107 Anderson St., BP# 2016-02705 building code plan review comments

Jeanie Bourke
Code Enforcement Officer/Plan Reviewer

MAIN FLOOR

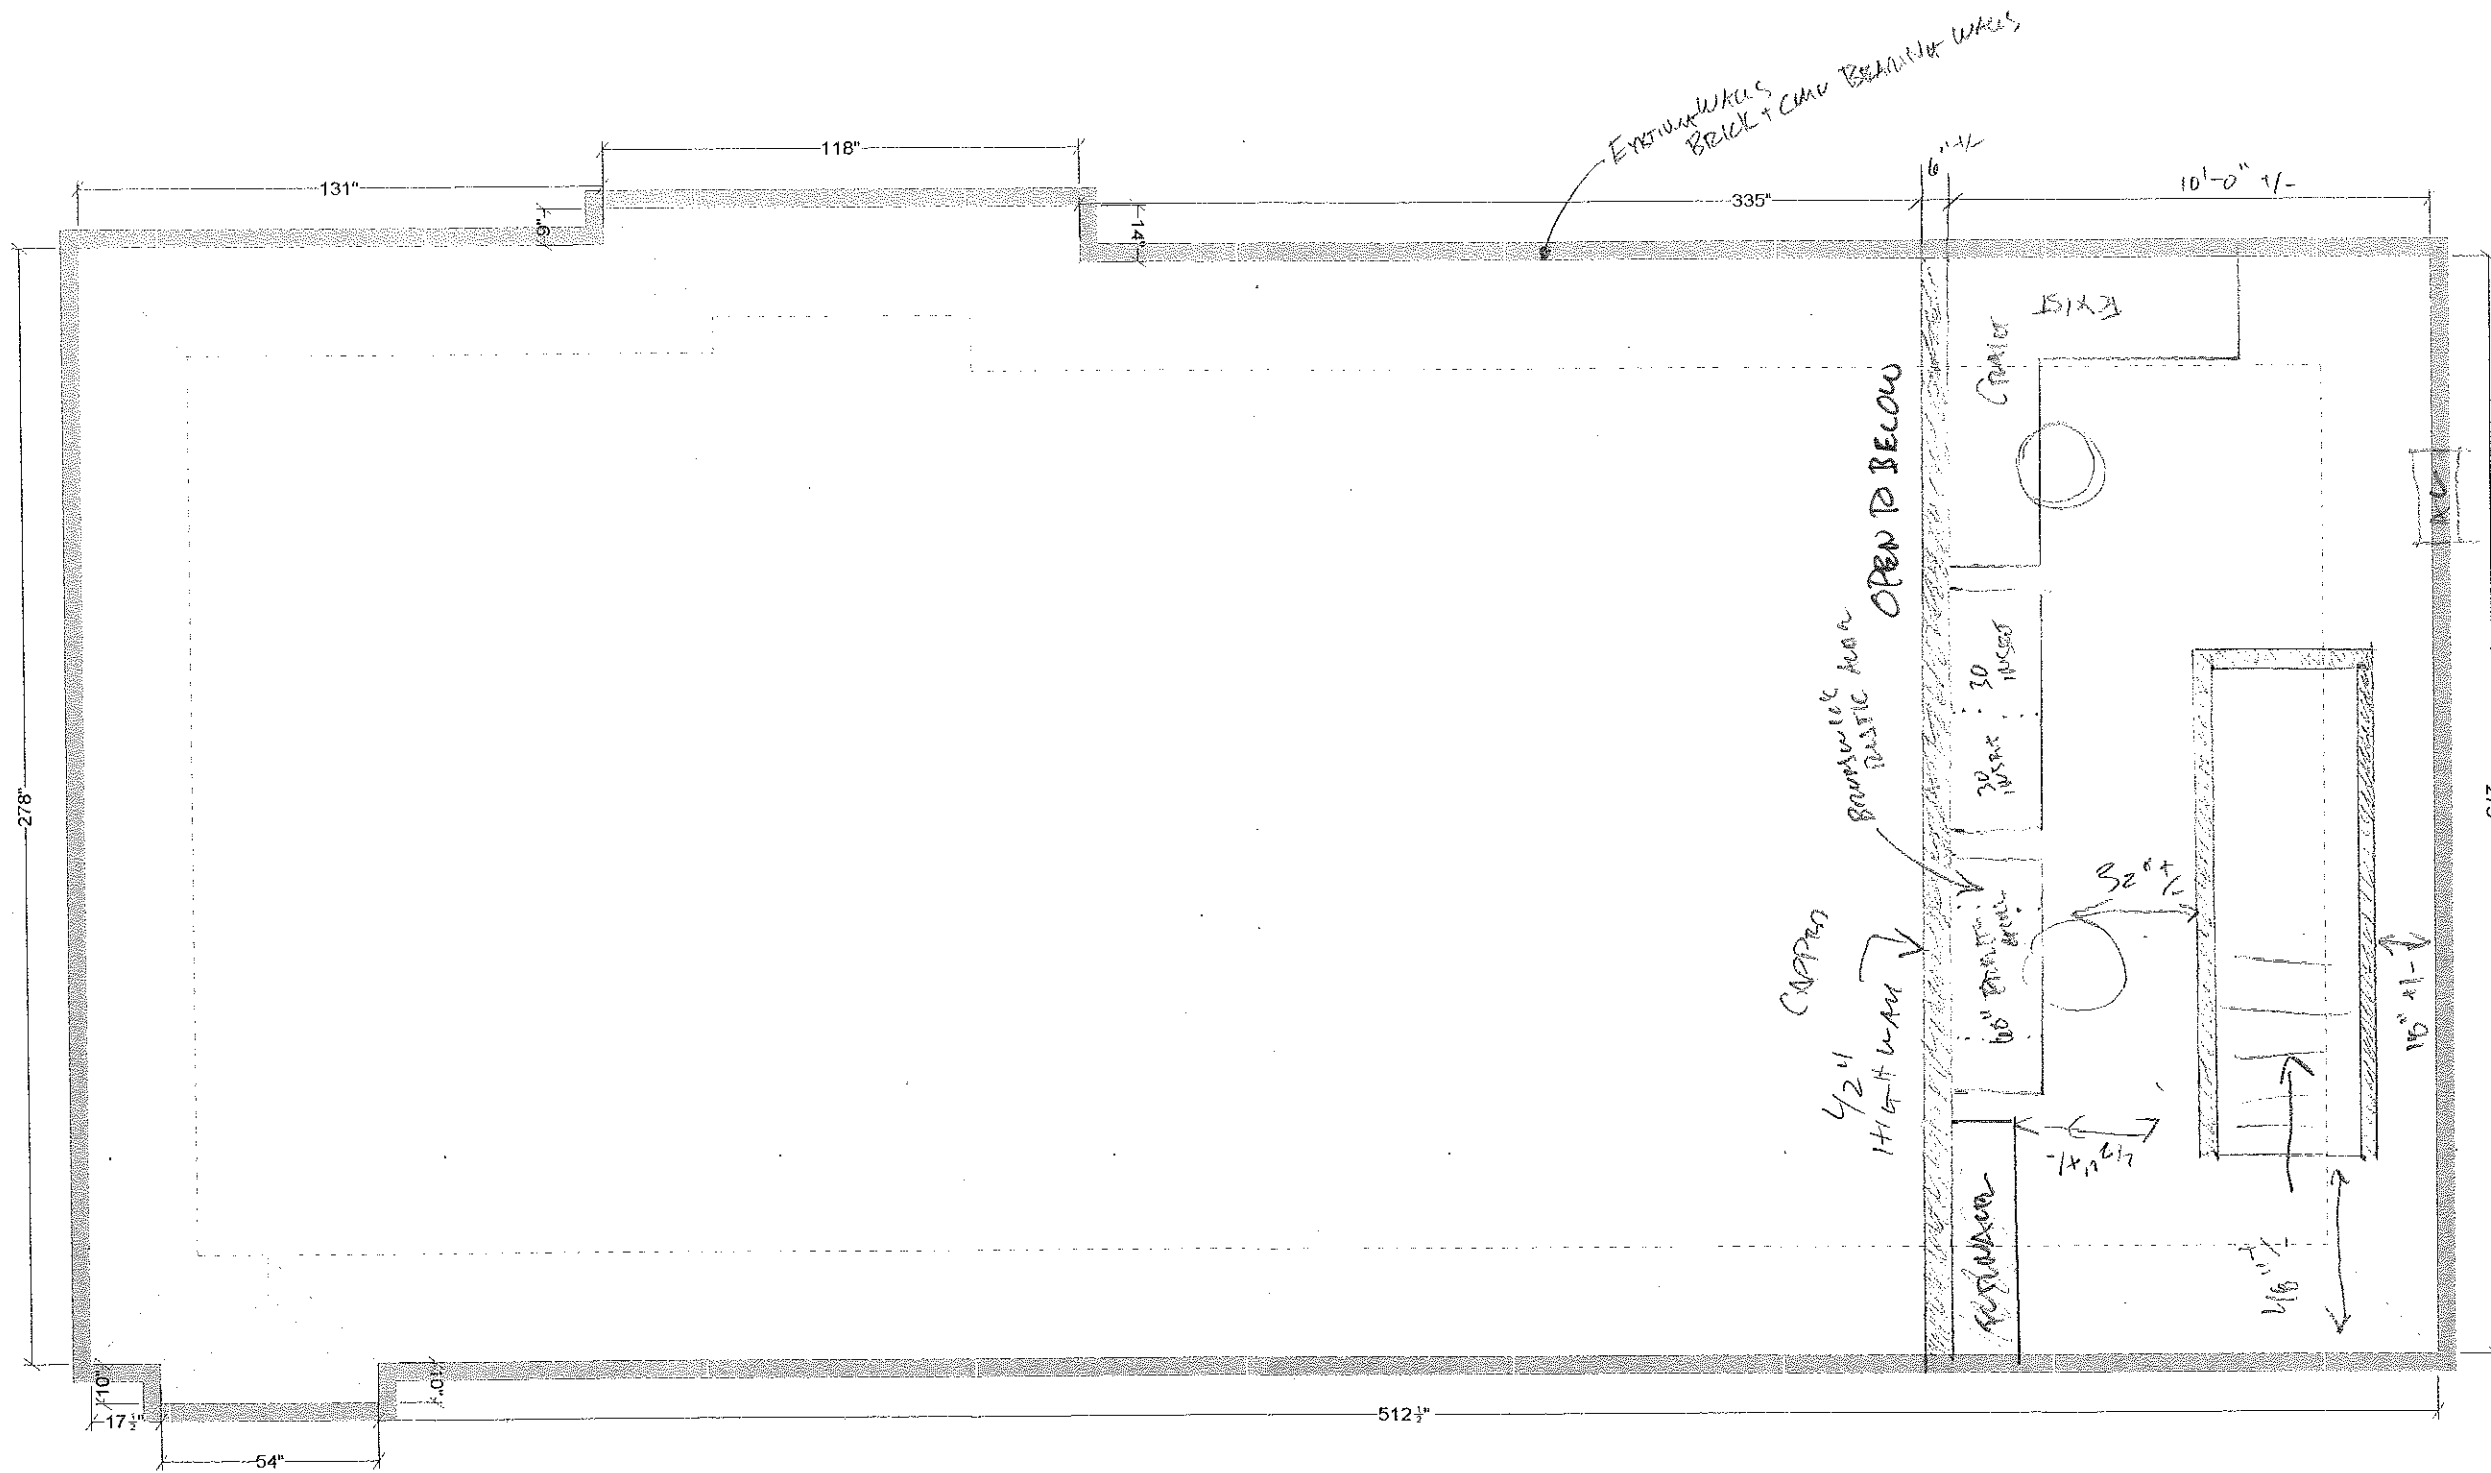
1. The plans do not show any construction details for the project scope of work. Please provide a narrative or plans that detail this information, e.g. new wall locations, materials, doors, ceilings, windows, etc.

3. The copy of this plan is of poor quality and does not clearly show exit doors or any overhead door locations. Is there more than one exit? Is there an exit at the bottom of the stairs? I have read the email reply you sent to Capt. Petrucci and the new plans, but it looks like there is only one exit door quite far from the mezzanine.

4. You note that there will only be 2 employees, however the retail component also has an occupant load based on the square foot area of this area. Please identify the area for retail and divide this by 60 to determine the occupant load. This is required for the Certificate of Occupancy.

- Basics are that there is an existing shell that we are adapting with new interior walls to create some spaces for the storage of our granite slabs and kitchens displays for retail.
- I noted on the attached updated plans that the perimeter walls, ceilings, floors are all existing, as well as the floor framing for the mezzanine
- Our new construction is limited to the walls needed for the main floor storage, display, and bathroom areas, and for the half walls of the mezzanine.
- Materials: New wall construction is 2x4 walls with ½" drywall in all locations.
- Doors: We are only adding (2) interior doors. One door to the bathroom and one to the room opposite the bathroom.
- Ceilings: Existing
- Windows: Existing

- There are (2) exit doors, but they are right next to each other. One exits into a vestibule of the adjoining space and the other exits directly onto the sidewalk
- No, there is not an exit at the bottom of the stairs
- Yes, there is (1) overhead door approx. 17' Wide x 13' Tall adjacent to the passage door to the sidewalk.

- Retail area is designated on the attachment and is approx. 38'x12' which is 456SF
- Total Retail Load = 8 Occupants
- Total Employee Load = 2 Occupants
